DRB Application No.: <u>07DRB-00557 (SBP)</u>	Project # <u>1004997</u>
Project Name: <u>TOWER WEST SUBDIVISION</u>	
Agent: <u>Mullen Heller Architects</u>	Phone No.: <u>268-4144</u>

6. **Project # 1004997**
07DRB-00557 Minor-SiteDev Plan
BldPermit/EPC
- MULLEN HELLER ARCHITECTURE agent(s) for 98TH TOWER JACK LLC request(s) the above action(s) for all or any portion of Lot(s) B-1-A, **TOWER WEST SUBDIVISION**, zoned SU-1 for C-1 and R-2 uses, located on TOWER RD SW between 98TH ST SW and 97TH ST SW containing approximately 2 acre(s). [REF: 06EPC00952, 06EPC00953, 07EPC00105] [Catalina Lehner, EPC Case Planner] (L-9) **THE SITE PLAN FOR BUILDING PERMIT WAS APPROVED WITH FINAL SIGN OFF DELEGATED TO TRANSPORTATION DEVELOPMENT FOR THE CITY STANDARD WORK DRAWING NUMBERS, A WIDER CROSS- ACCESS- SIMILAR- TO- THE- PLAT- AND- PLANNING FOR CATALINA LEHNER'S INITIALS AND 3 COPIES OF THE PLAN.**

DATE: May 7, 2007
TO: Sheran Matson, DRB Chair
FROM: Catalina Lehner, Senior Planner *CL*
RE: Project #1004997, Tower/98th Building

Proposed Retail Building  
 Southeast Corner of 98th Street and Tower Road  
 Albuquerque, New Mexico  
 Site Plan For Building Permit

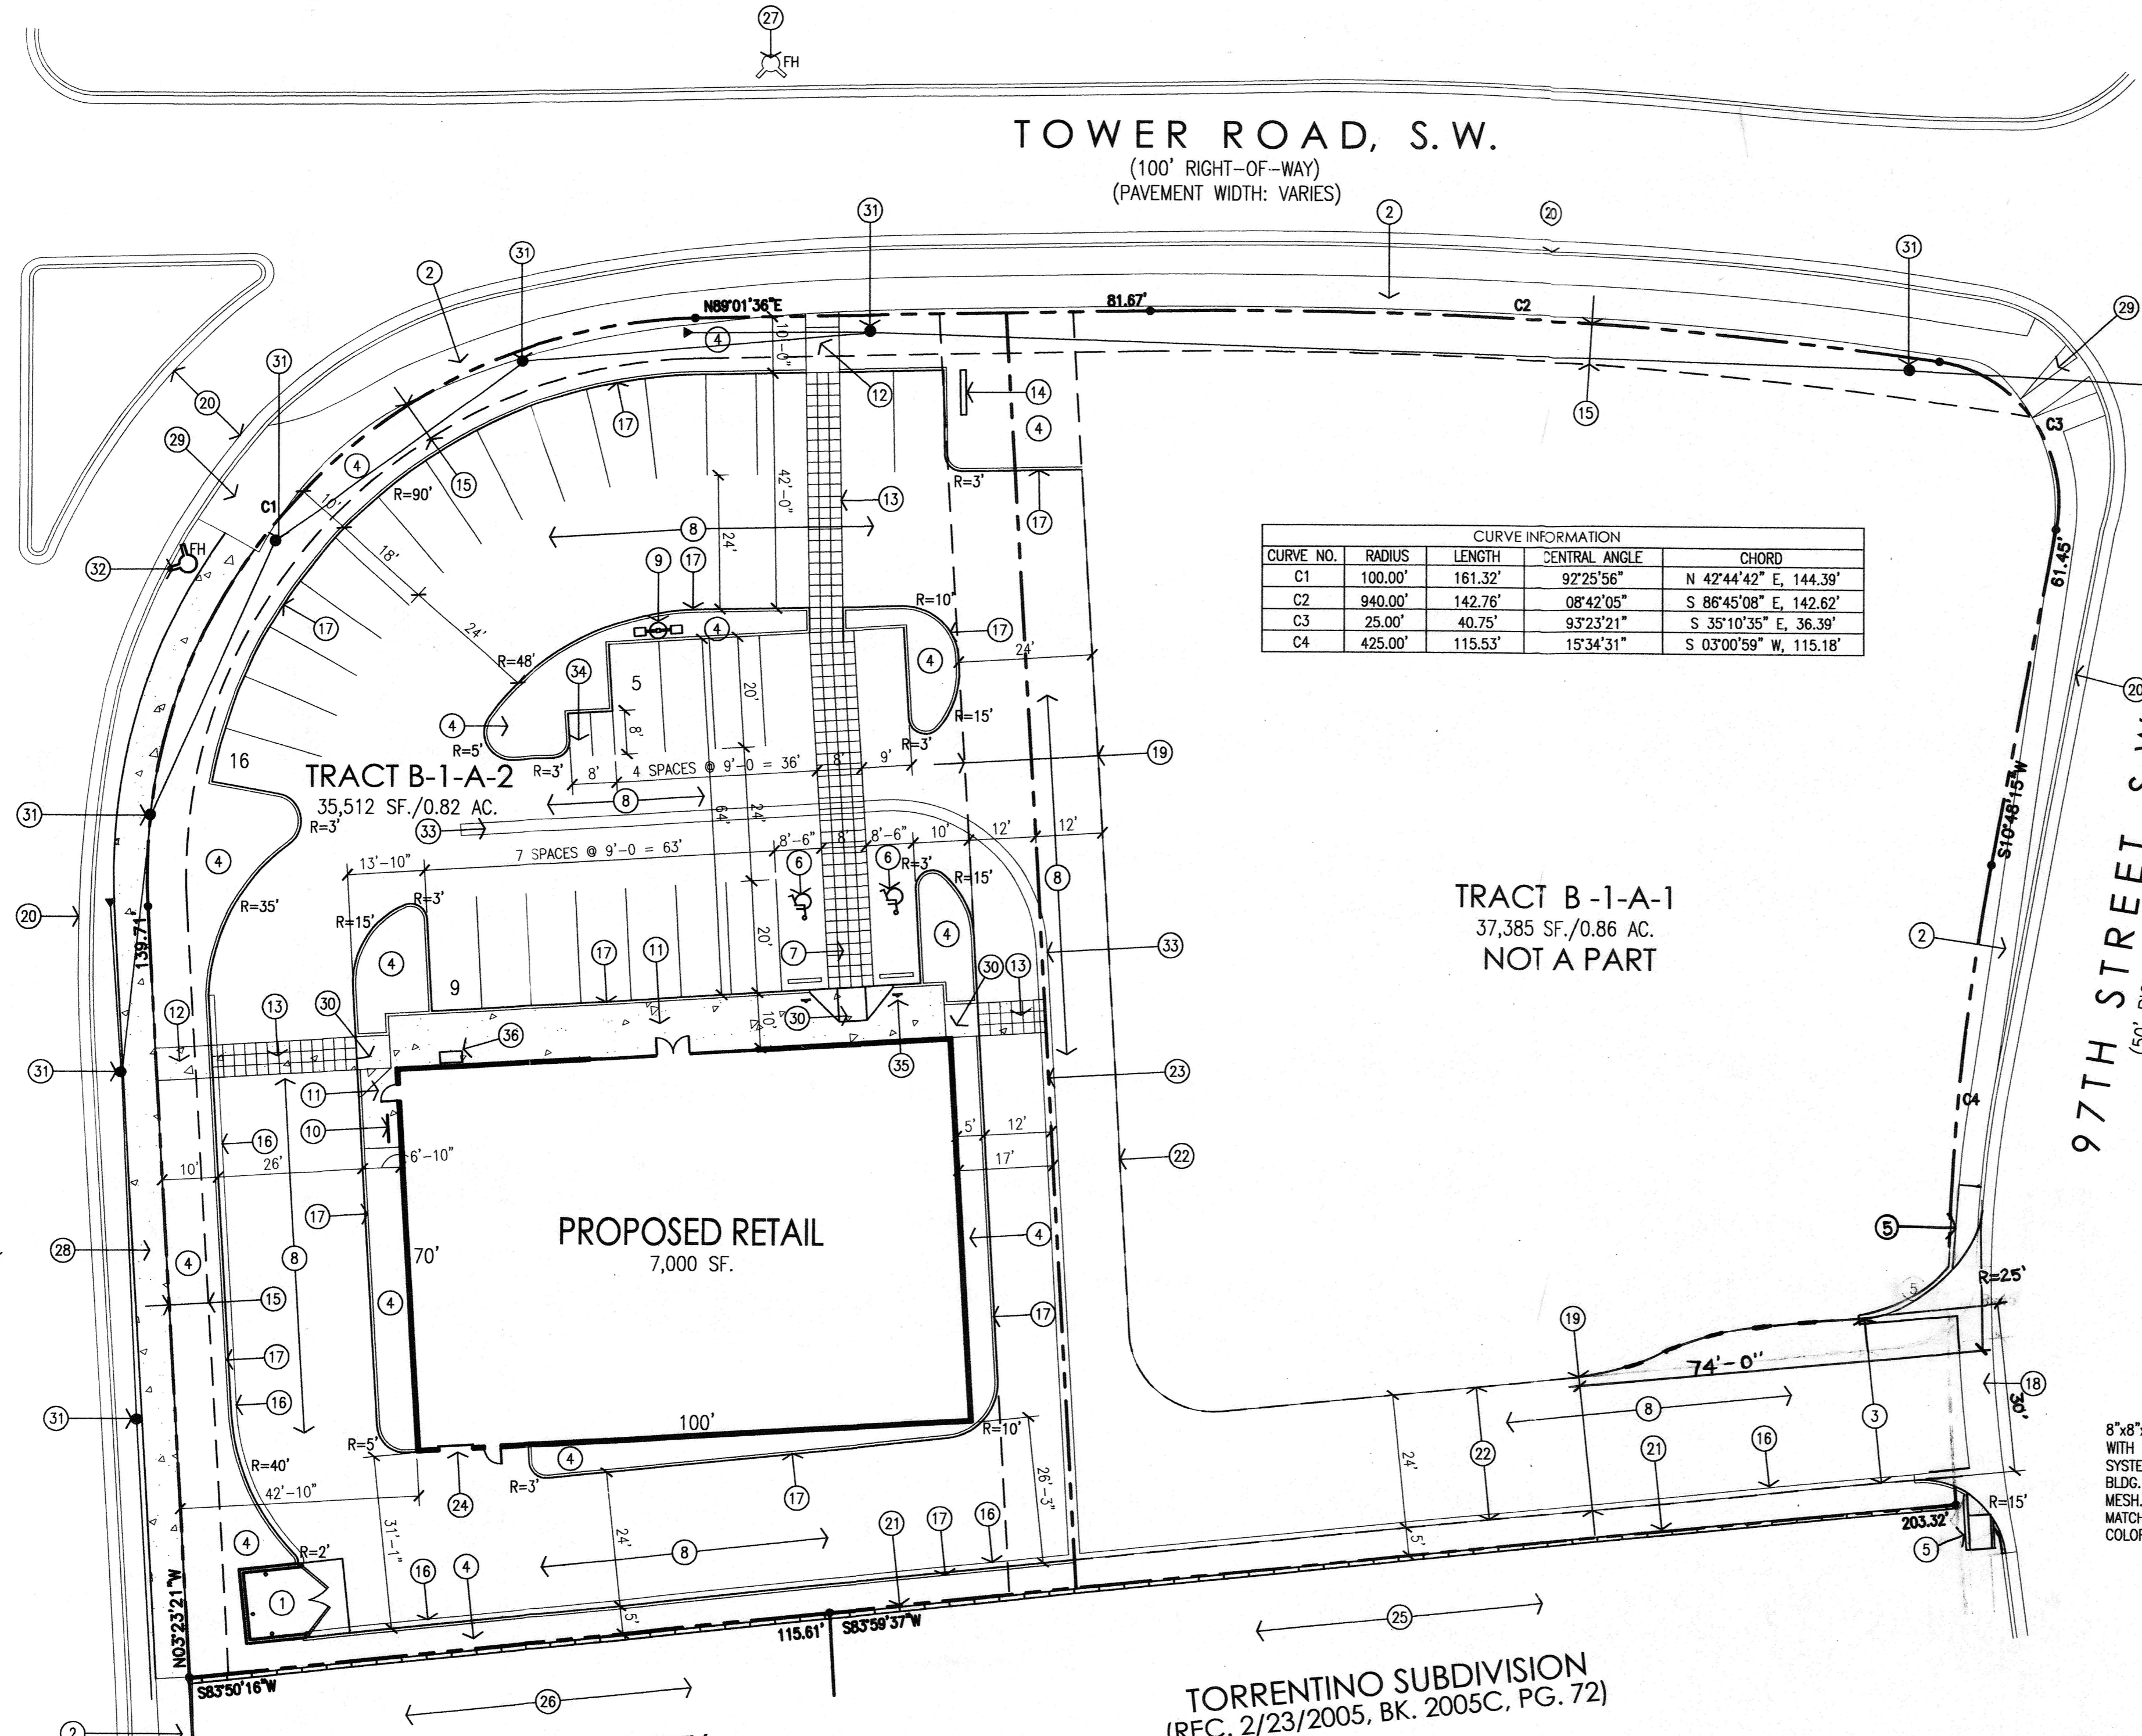
TRANSPORTATION: • City standard drawing no.'s work with Public ROW.
• wider cross access

sheet: A001

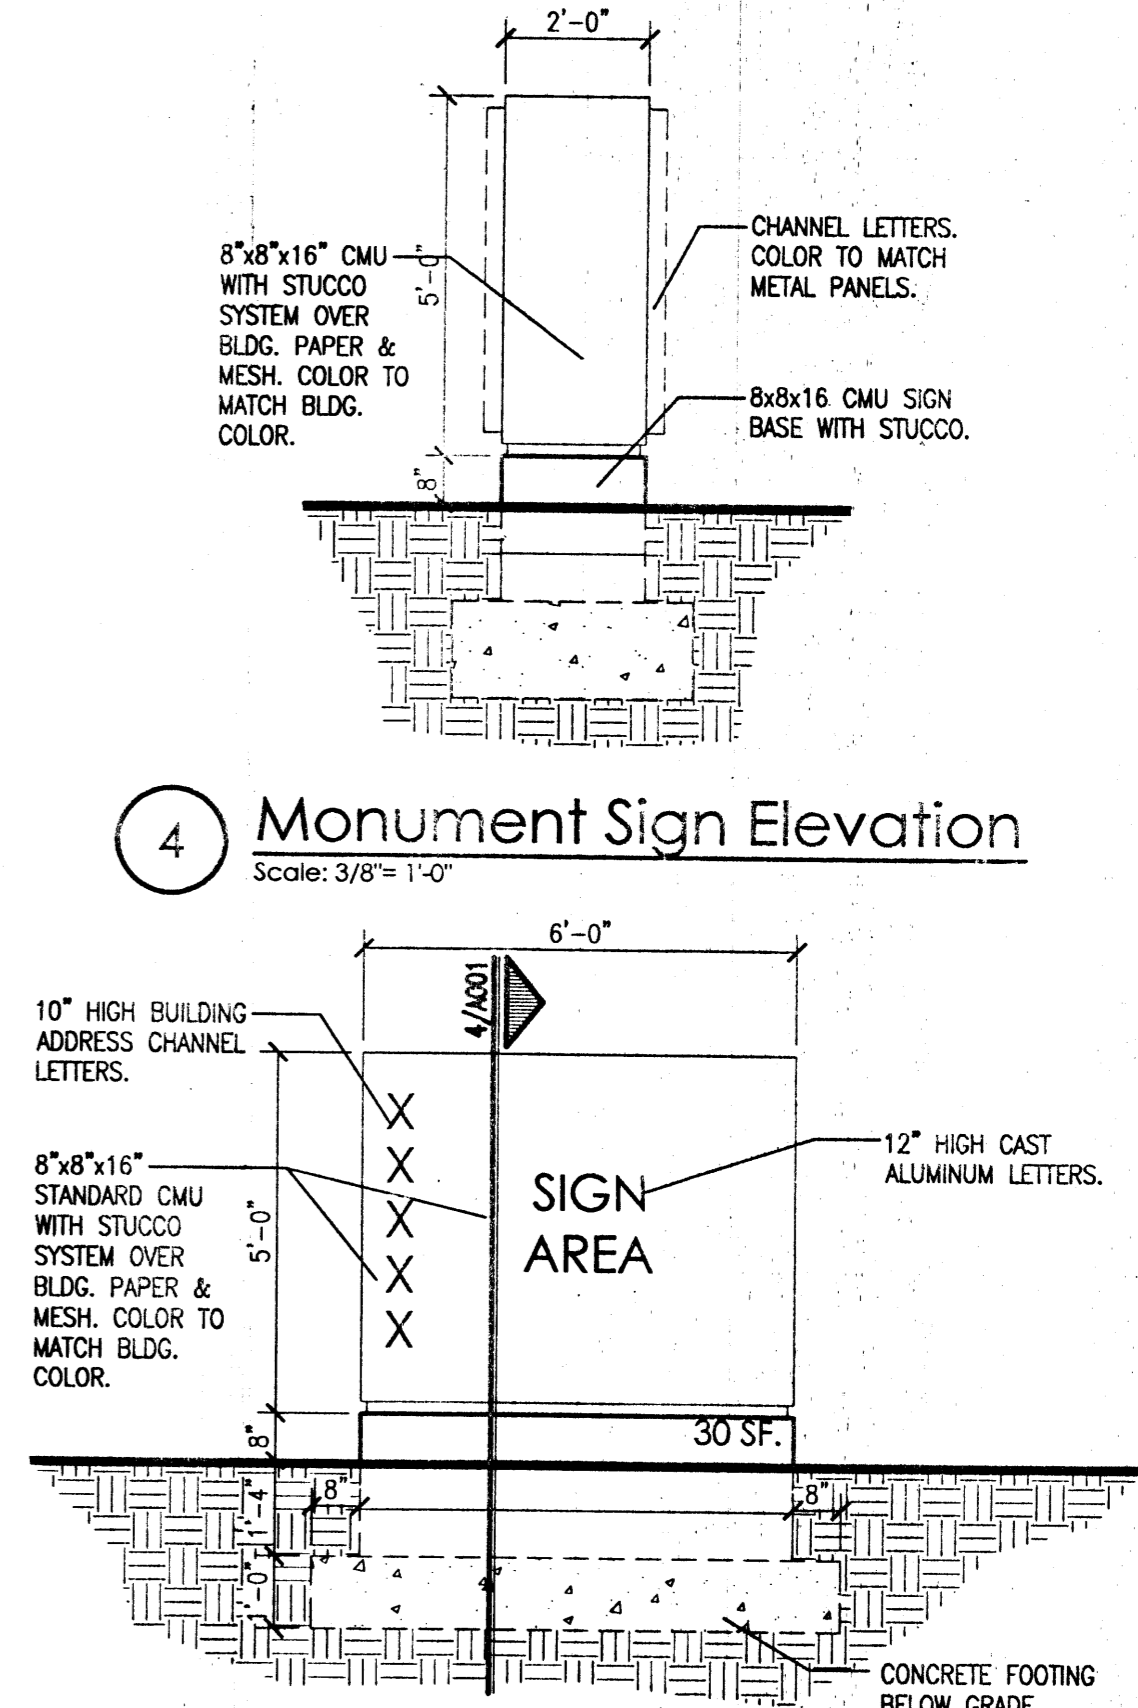
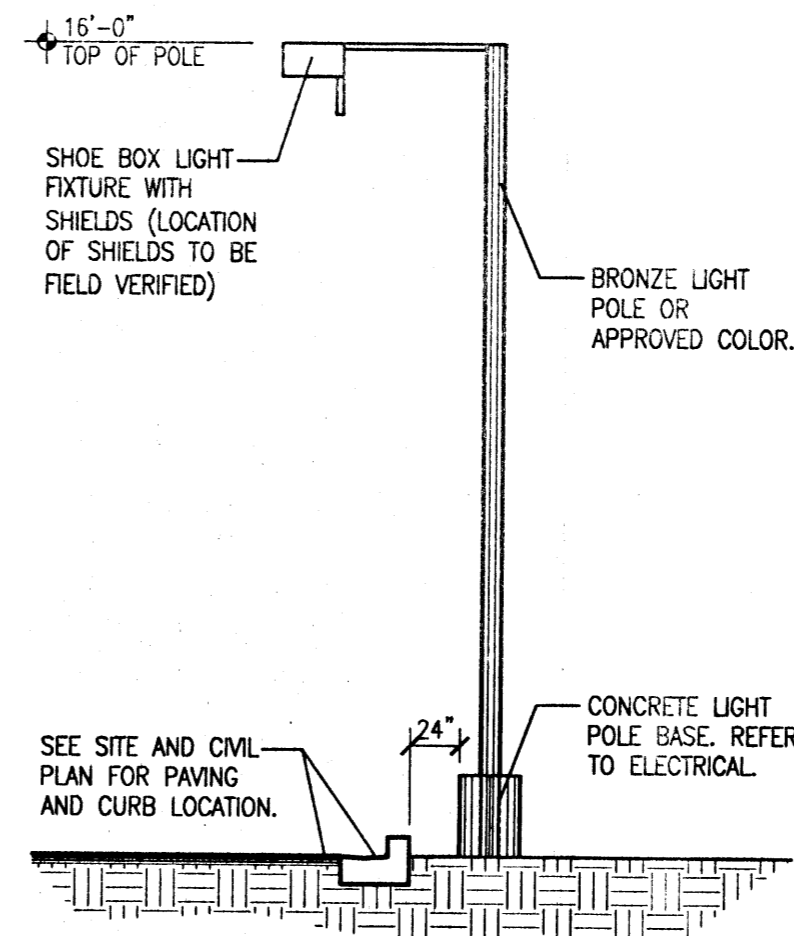
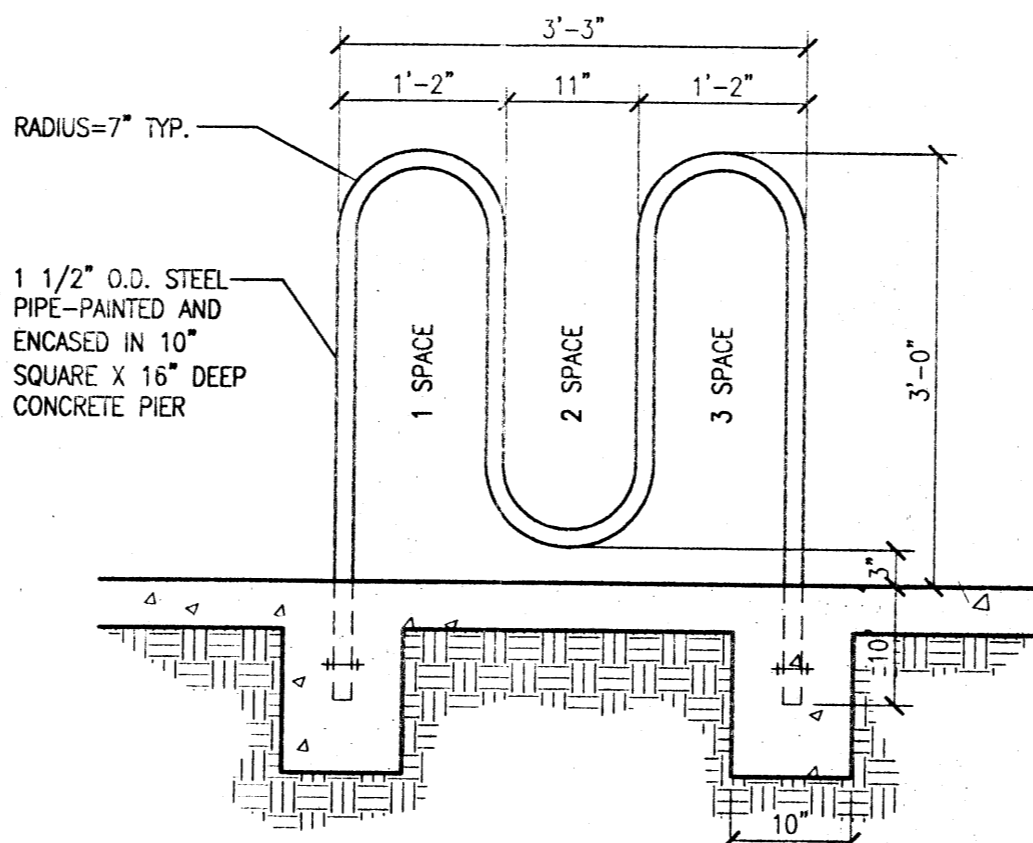
Also, I think it is appropriate to remove the word "proposed" from the keyed notes on Sheet A001. The EPC has approved this Plan and the notes are no longer proposed.
